25 February 2022

TfNSW Reference: SYD17/01529/13
DPE Reference: SSD 8859

**EXHIBITION OF AMENDED REPORT ON EIS FOR ELIZABETH DRIVE SUBDIVISION
AT 1111-1141 ELIZABETH DRIVE, CECIL PARK**

Figure 8 | Original detailed concept plan of roadway changes

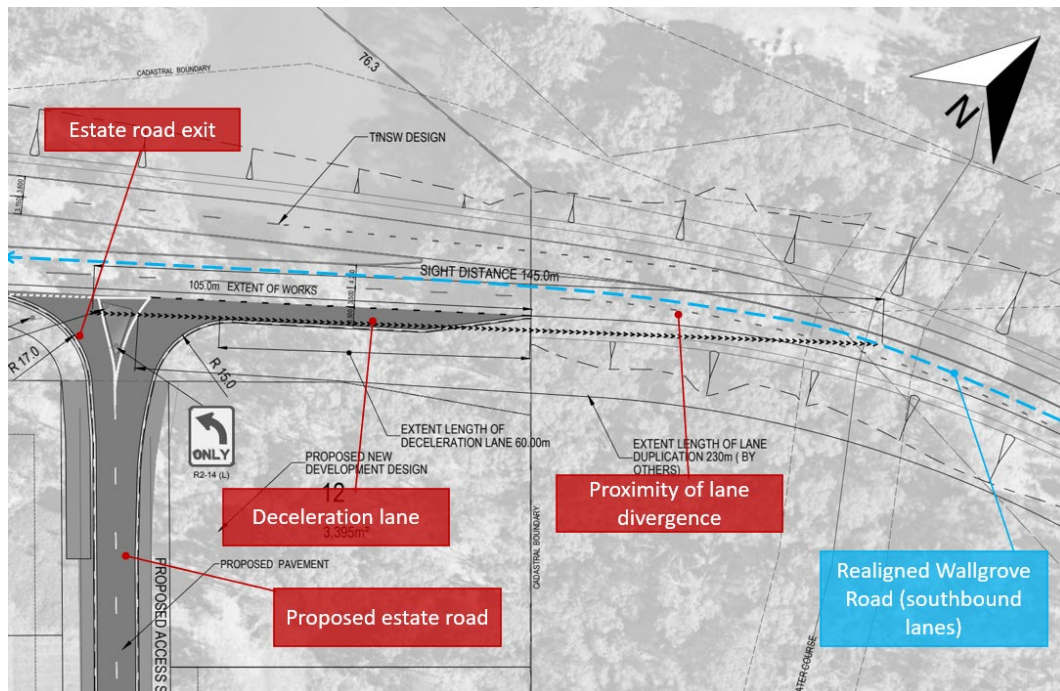
Please be advised that the proposed development and access arrangement to the site necessitates development of the second lane on future realigned Wallgrove Road to be extended further to the north. This is to ensure safe access and egress to/from the development site on future realigned Wallgrove Road.

TfNSW has undertaken a high level design review and please refer to **Attachment A** which shows the indicative design changes that would be necessary for the earlier development of the second lane (to be used as guide only).

TfNSW requests amended plans reflecting the design requirements at **Attachment A** and to remove any notation that the required works are to be undertake 'by others'.

Figure 9 | Final concept roadway and intersection design

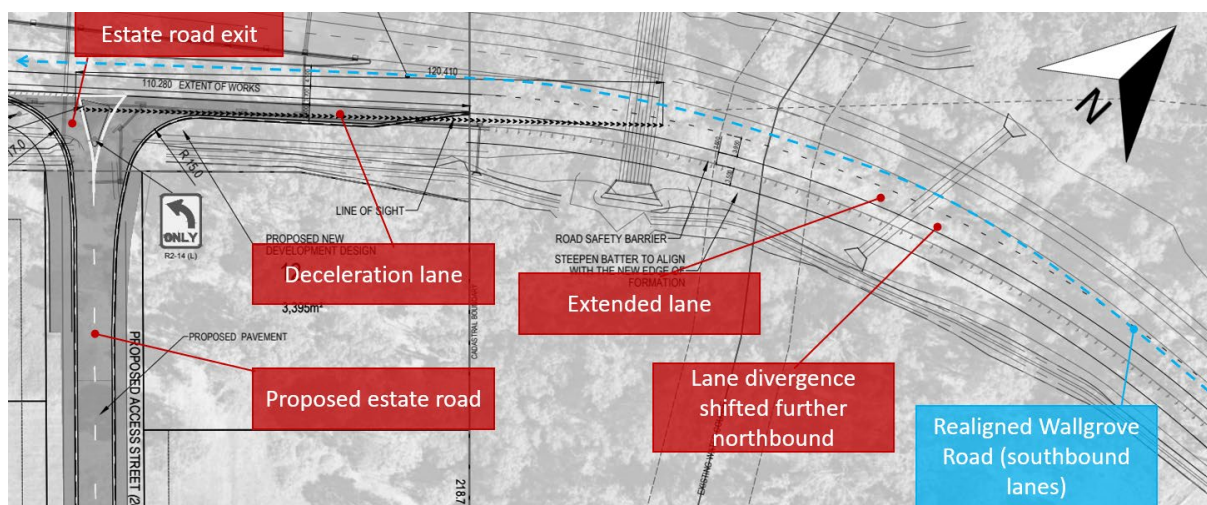
Therefore, the design and construction of the proposed access and subsequent changes to the current design of Wallgrove Road to incorporate the second kerbside lane extension should be at full cost of the developer and no cost to TfNSW.
